Art Board

3/28/09

Int'lly Existing BC

FIRE ESCAPE
340 FORE ST.

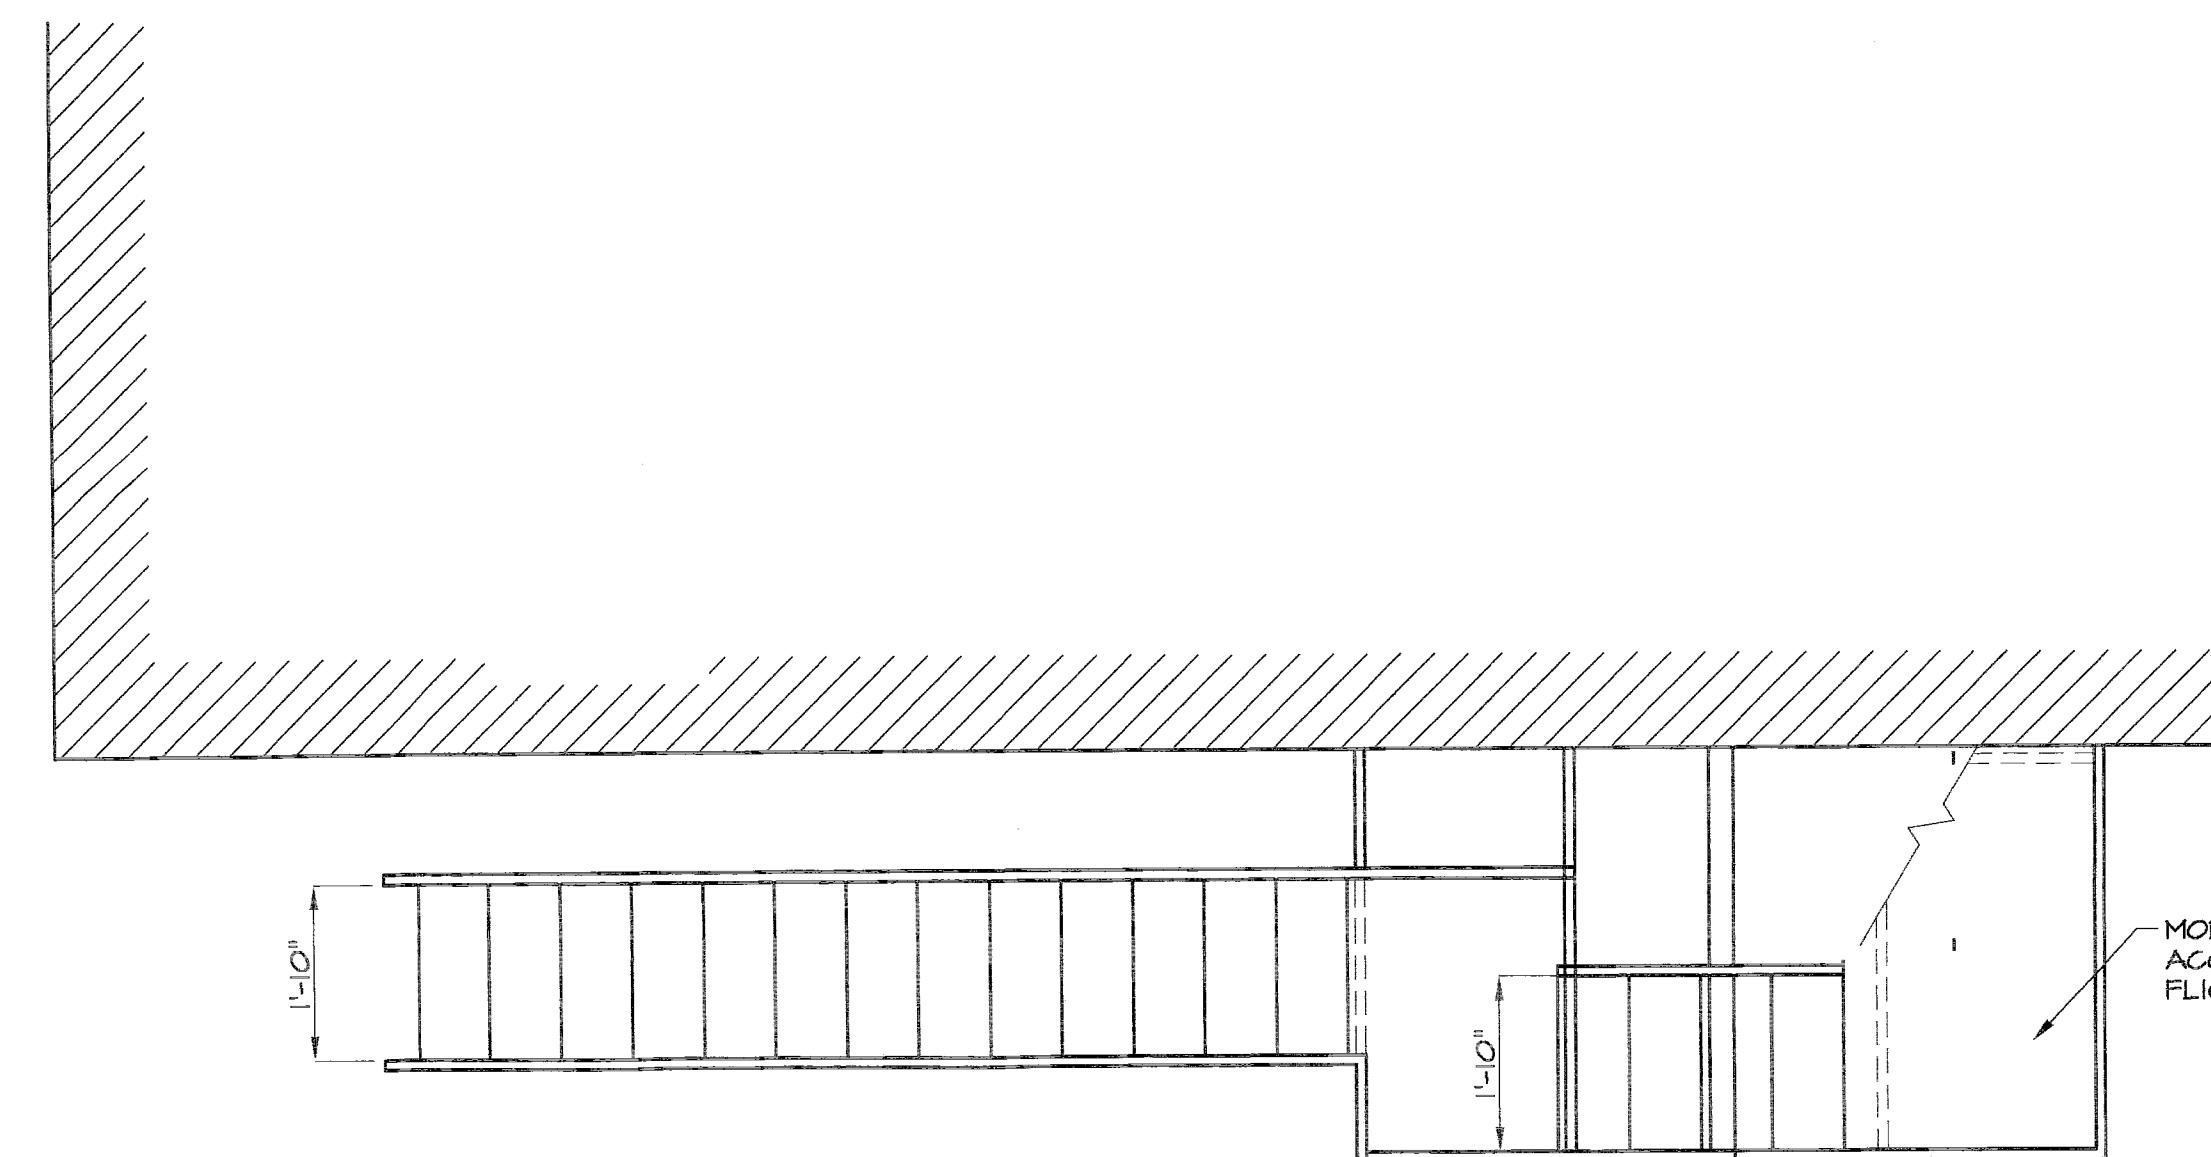
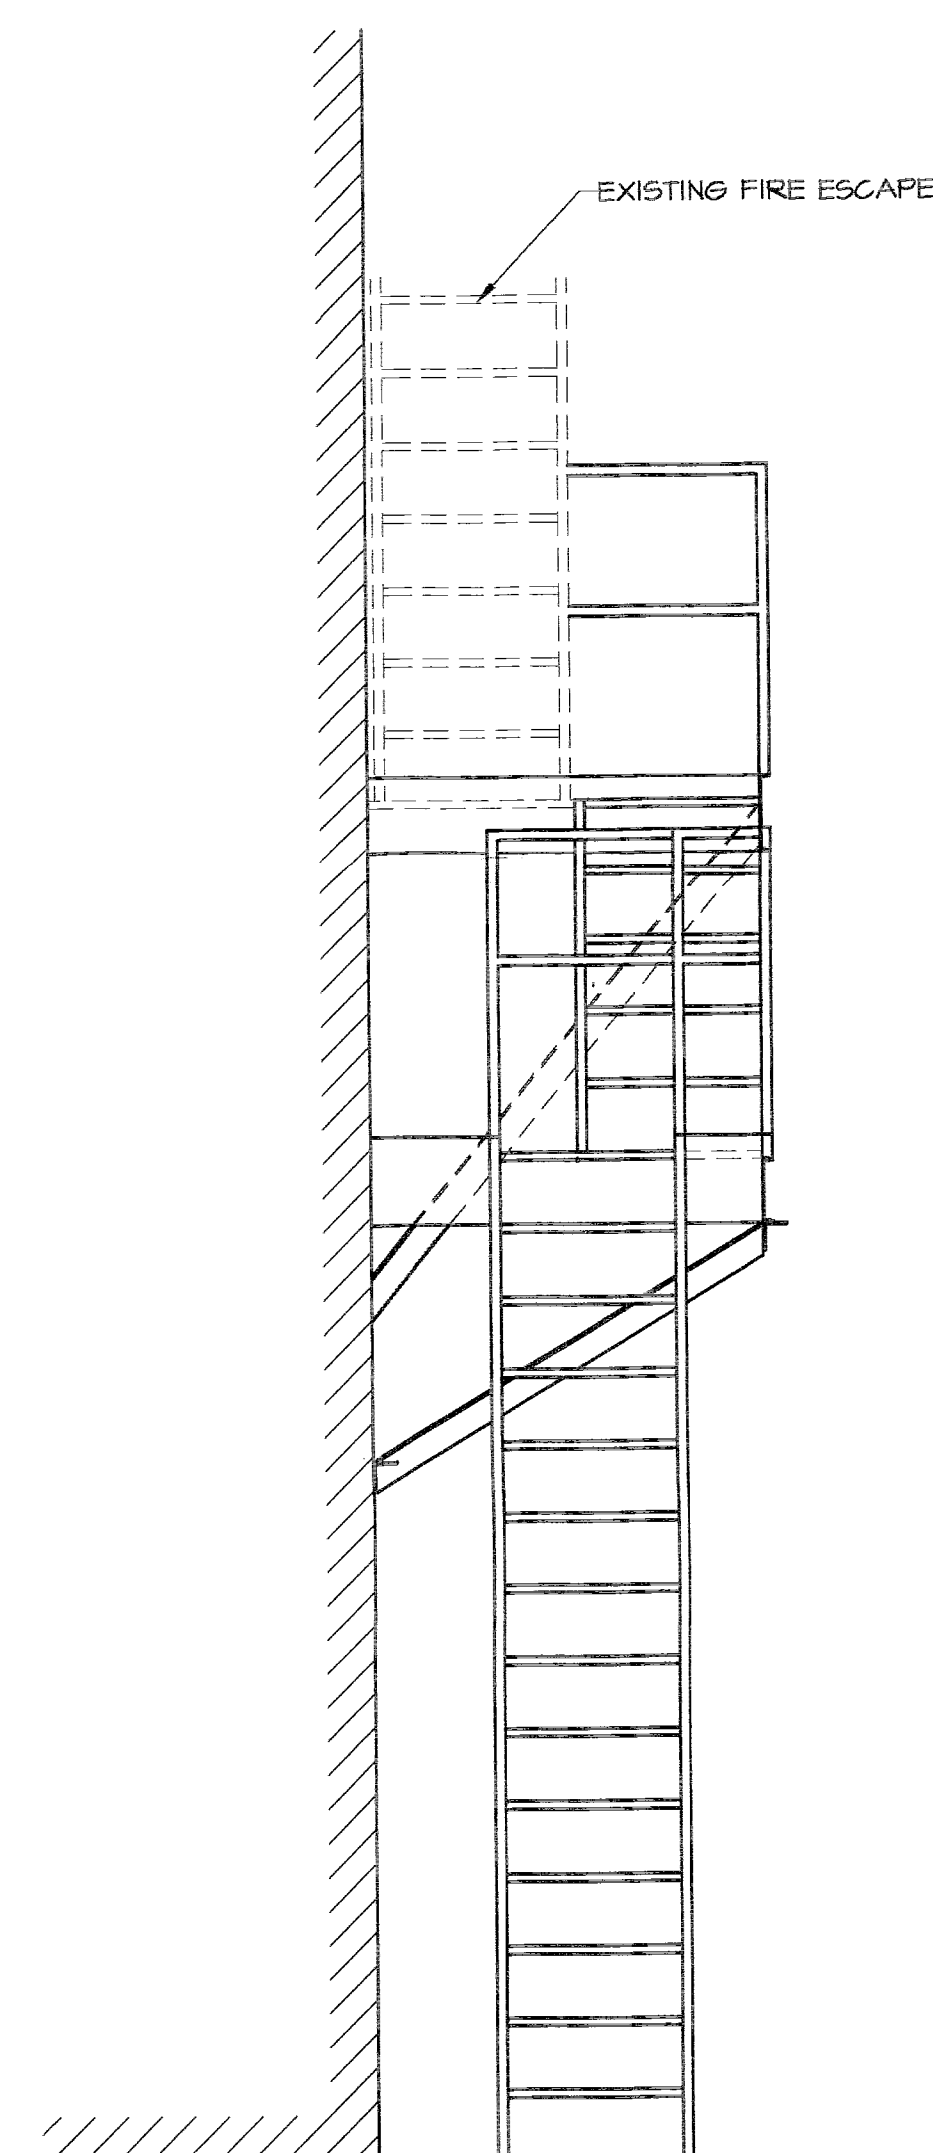
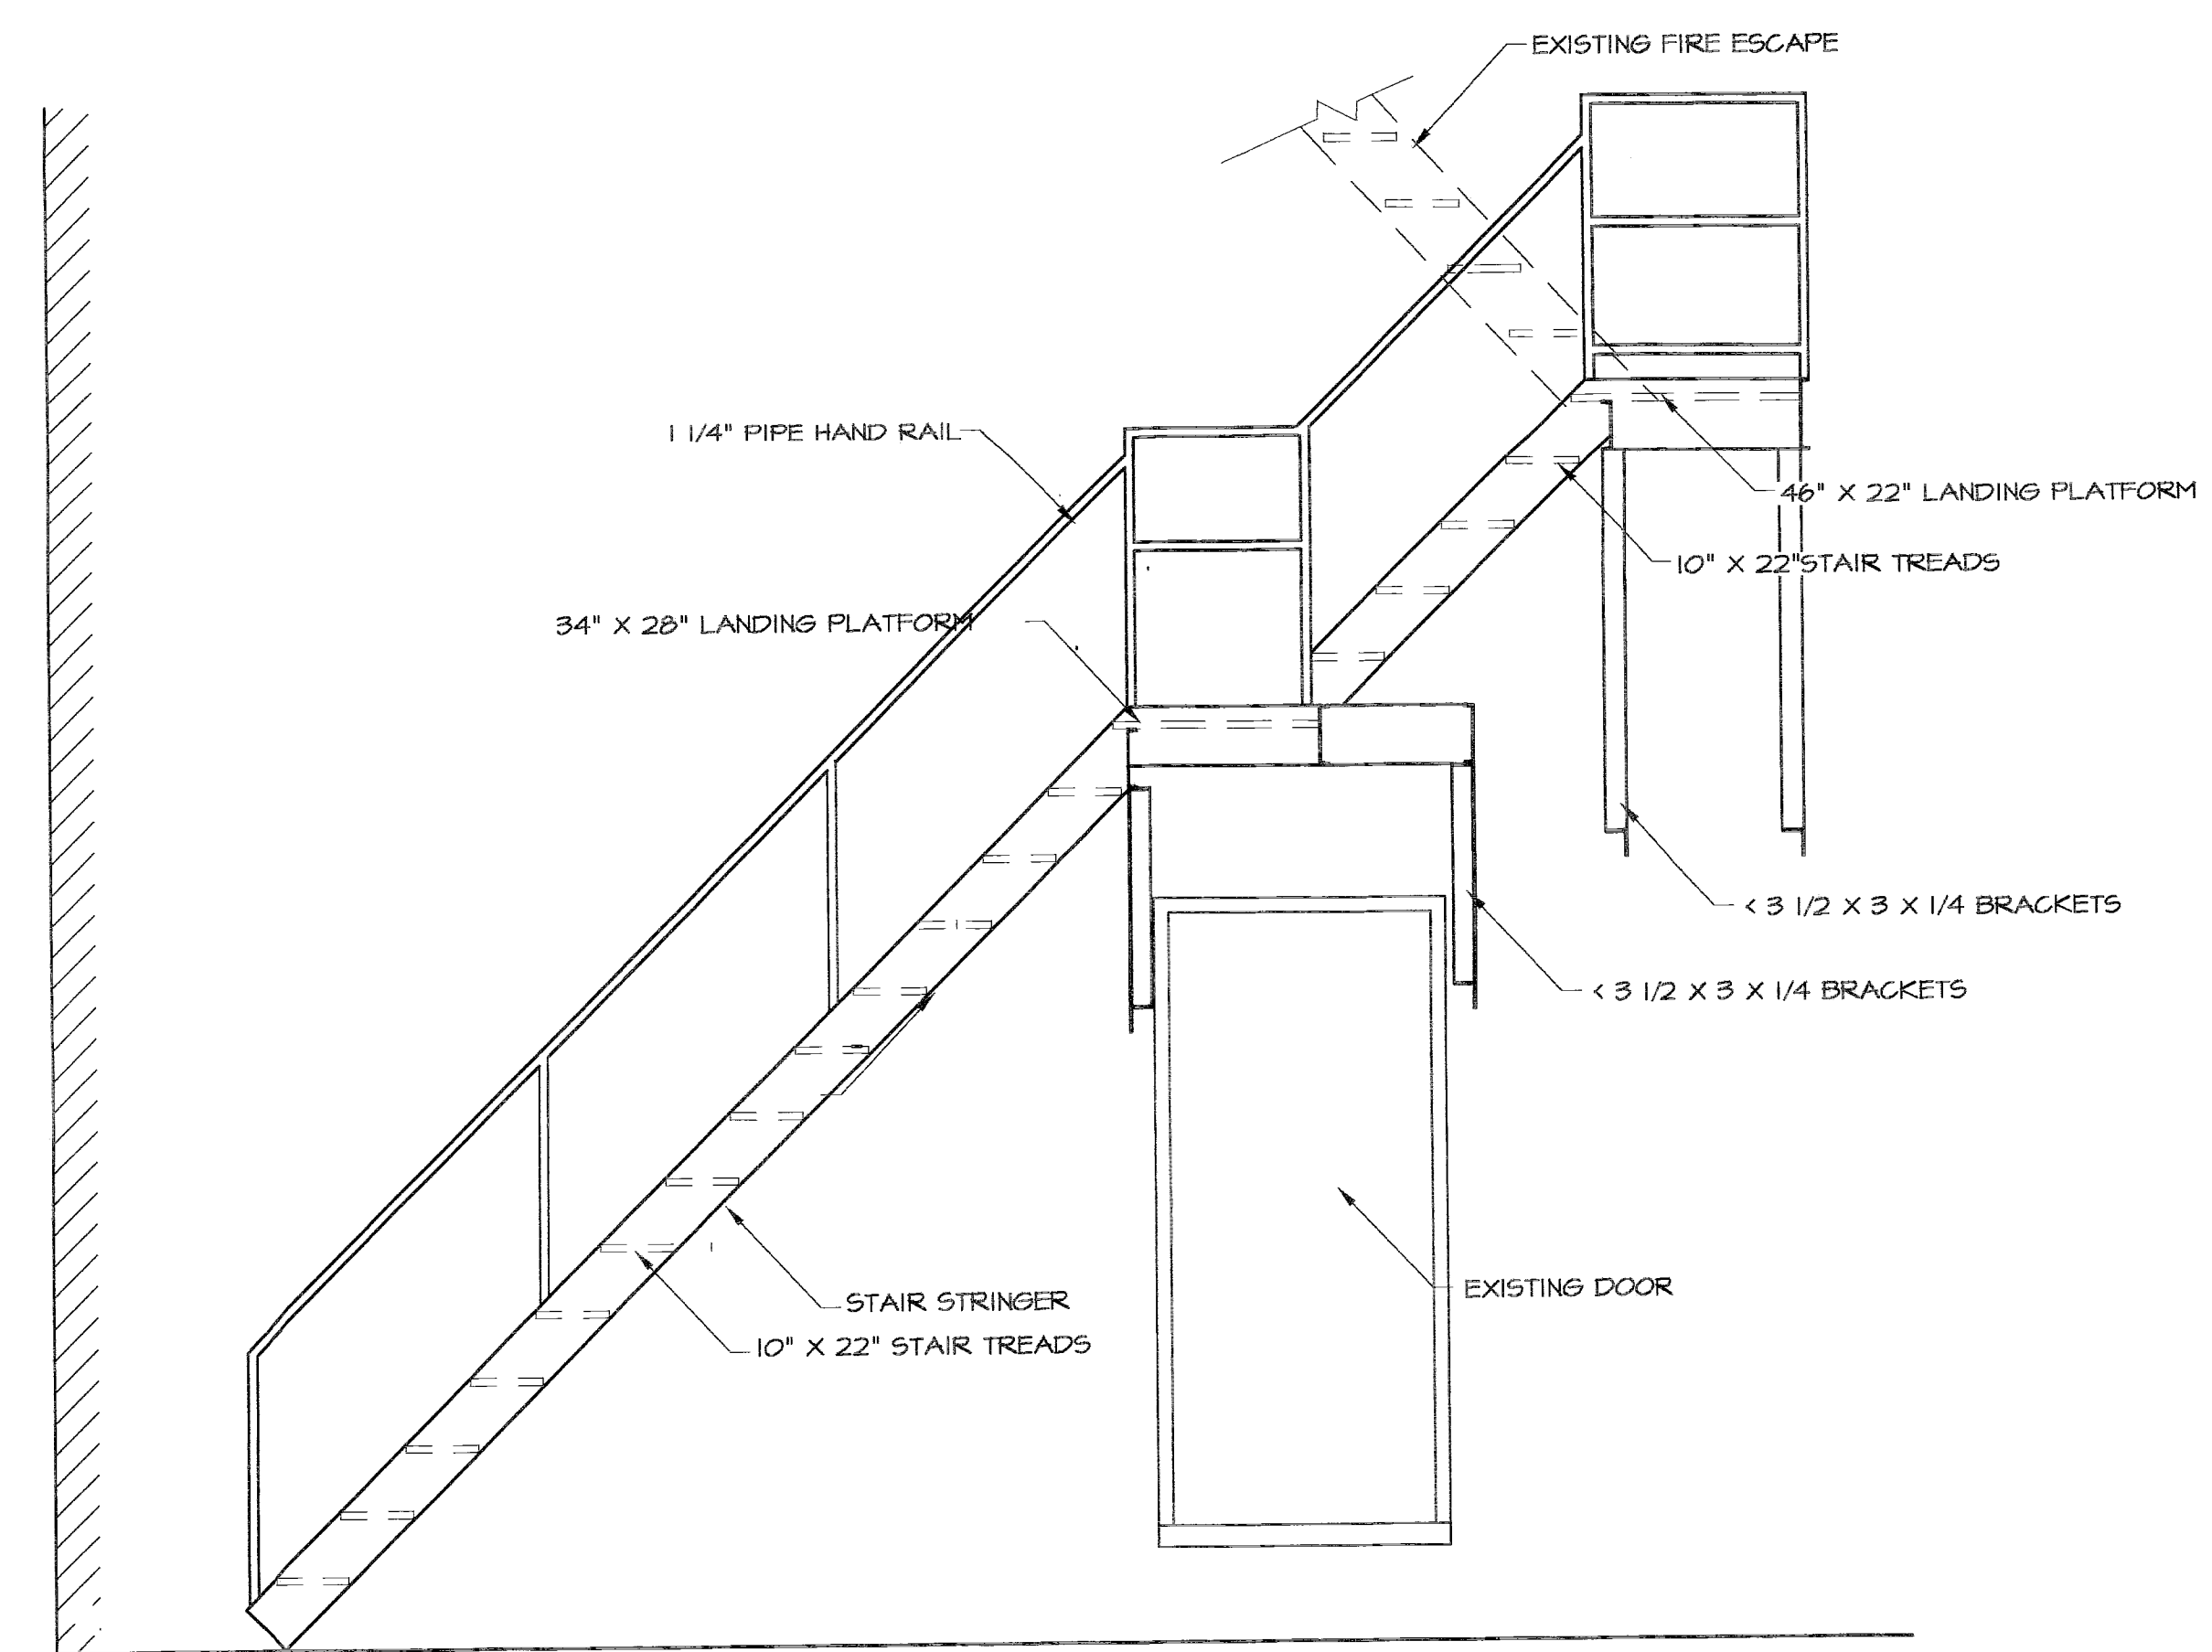
exits

1 exit = stairway

Residences by code req'd to have 2 ~

- existing fire escape ~

→ fire escape certified
or
sprinkler
